Reference: PA-0005318/01
Customer reference: 2026/90604
16 June 2026

Change of use of public house ground floor and basement to dental clinic and taxi office at THE BRIDGE, 159-161 MANCHESTER ROAD HUDDERSFIELD KIRKLEES HD1 3LE

Environment Agency Position

title General arrangement as proposed
number 24090D-02-P03
scale 1:50, 1:100
size A1

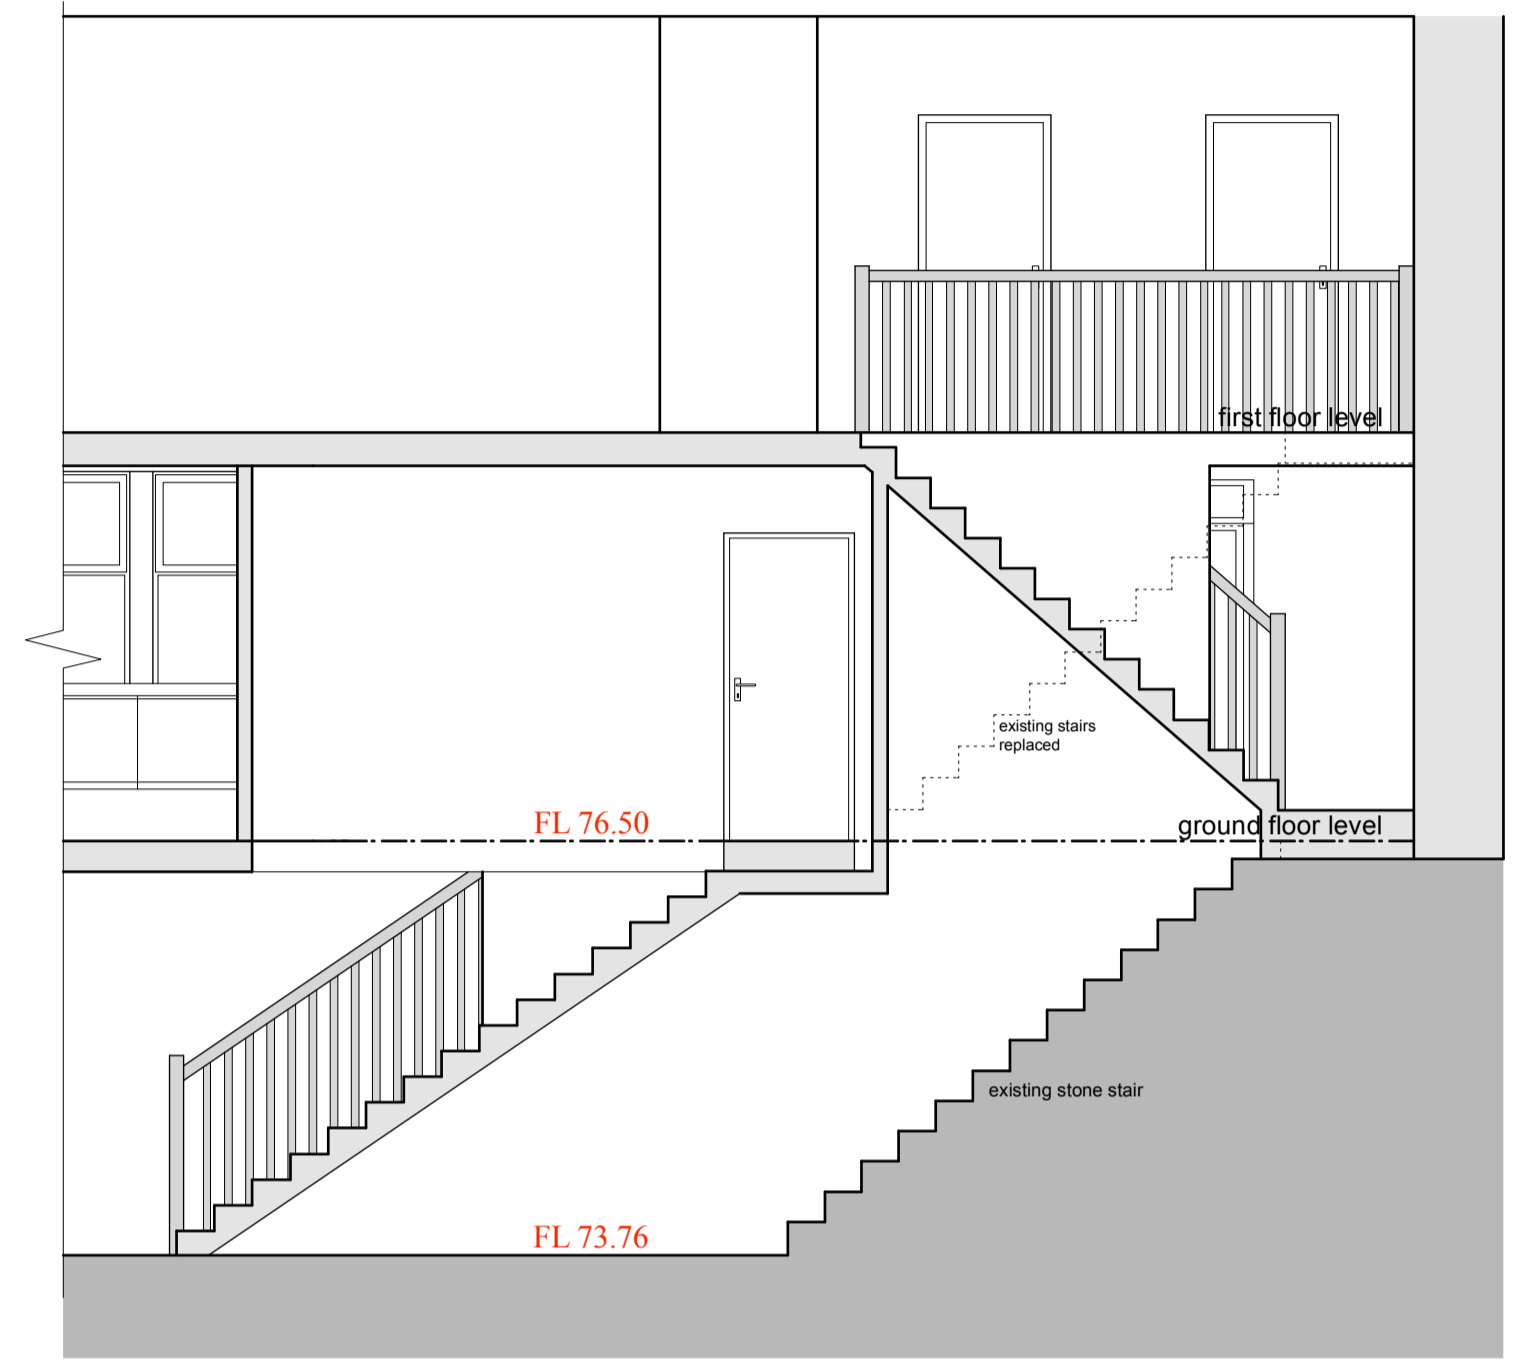
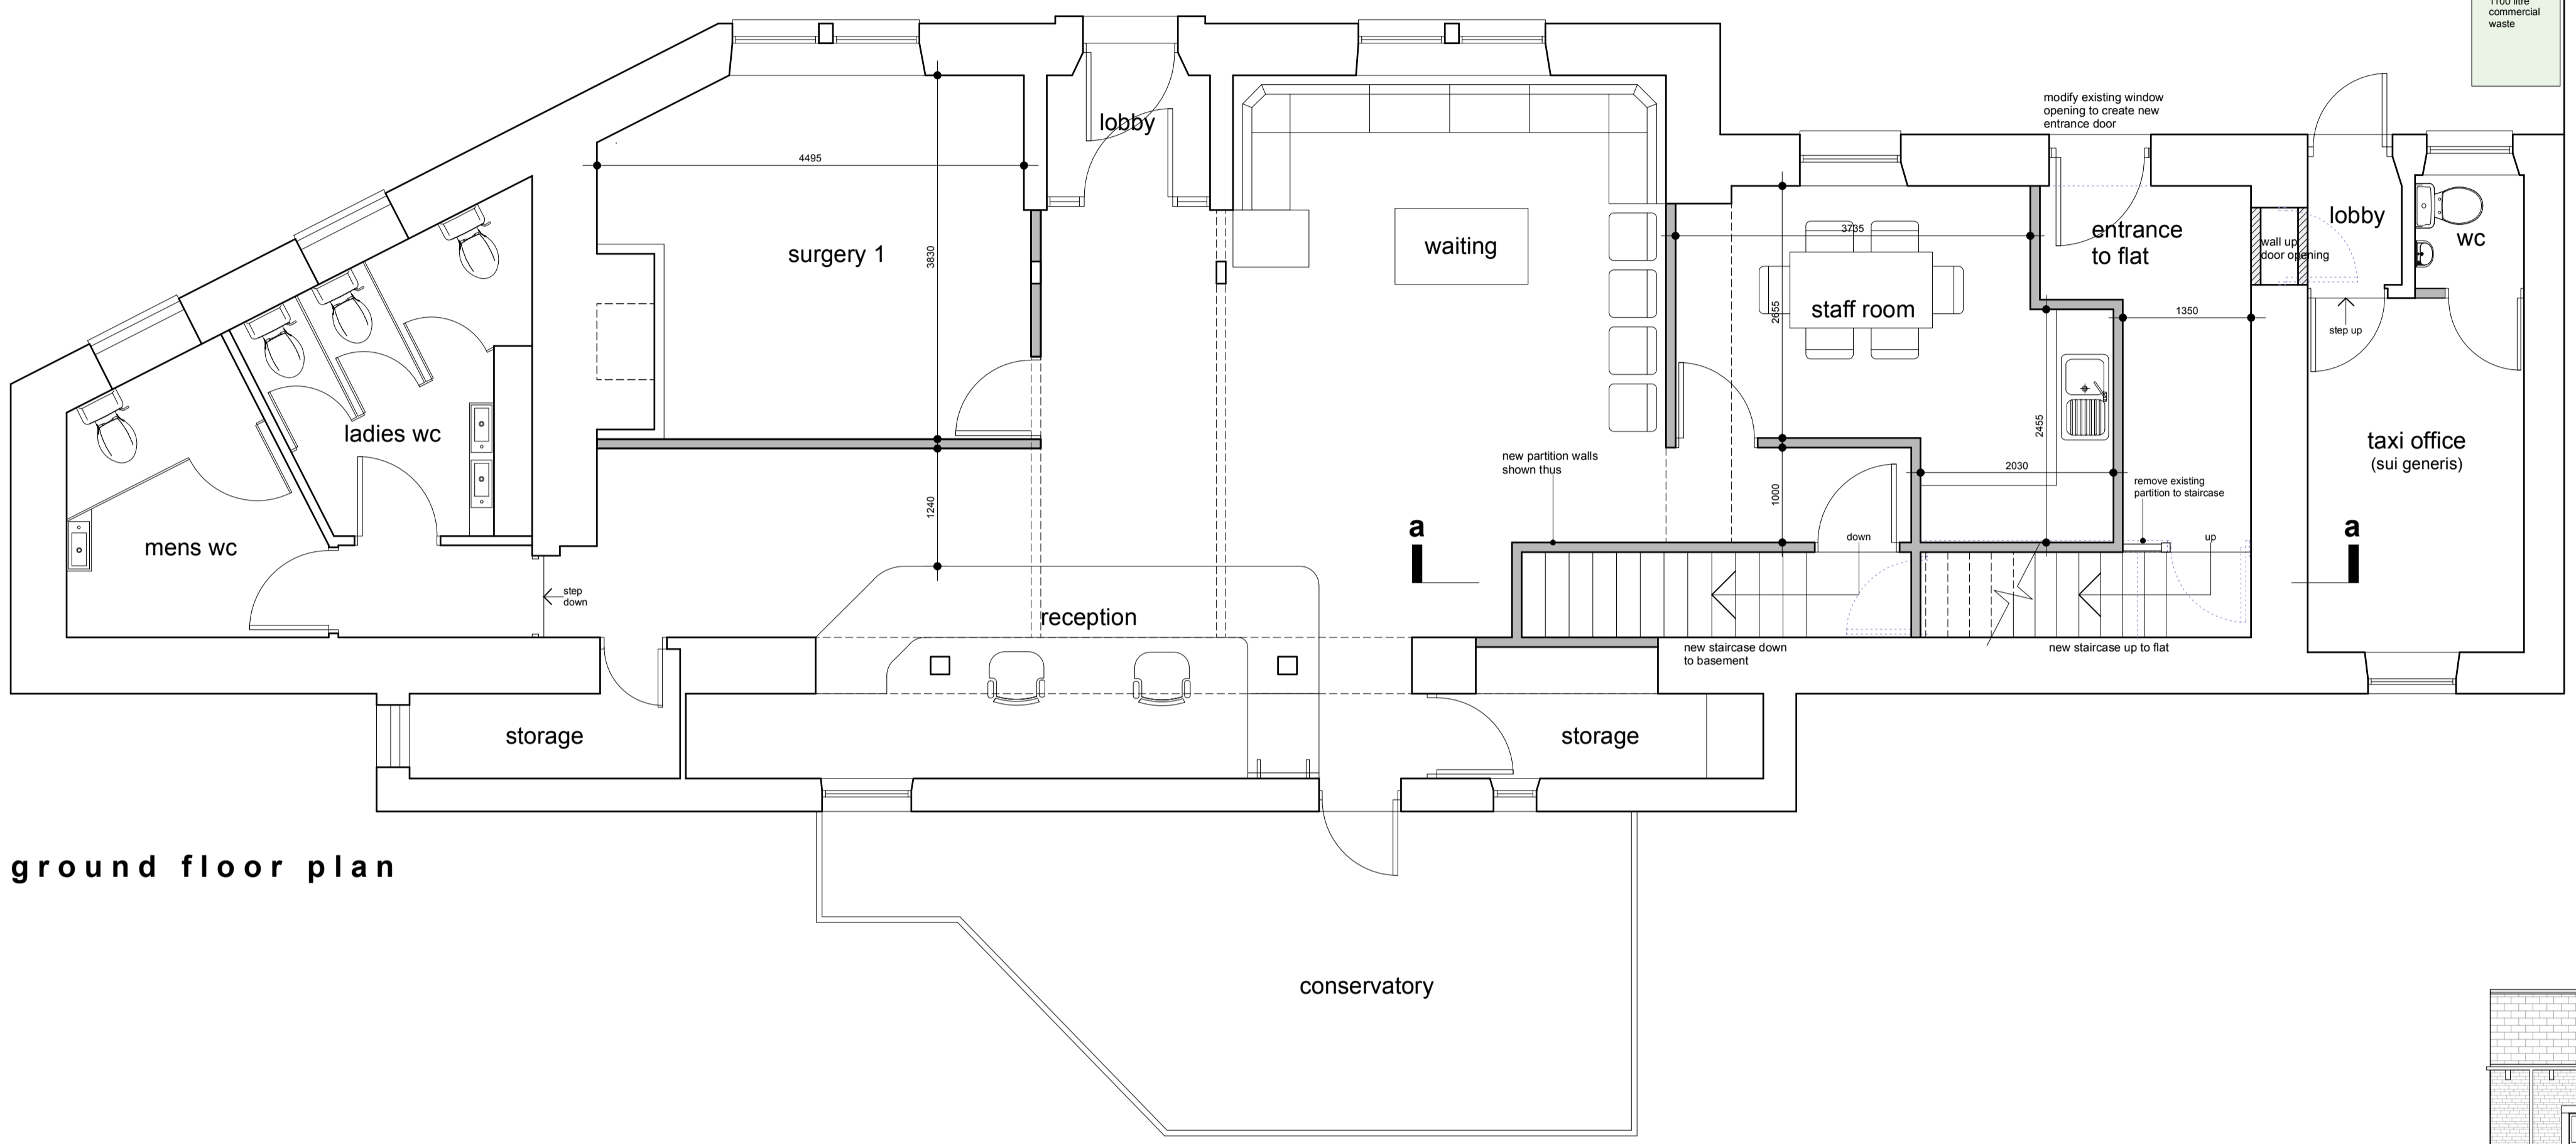
- We note this application is for the change of use of a public house to a dental clinic and taxi office on the ground floor and basement only and does not include any proposals for the first-floor residential accommodation.
- We note that the building is partly within Flood Zone 2 and 3a and that there is no increase to the footprint of the existing building.
- We note the Flood Risk Assessment submitted with this application states the classification as Less Vulnerable, however the proposed development for the dental practise would fall under More Vulnerable classification.
- We understand the threshold to the basement will be the same as the Ground Floor Finished Floor Level.

- Ground Floor finished floor levels for the dental clinic shall be set no lower than 76.50 metres above Ordnance Datum (mAOD)
- Resistance and Resilience measures as detailed in paragraph 6.19 of the FRA.
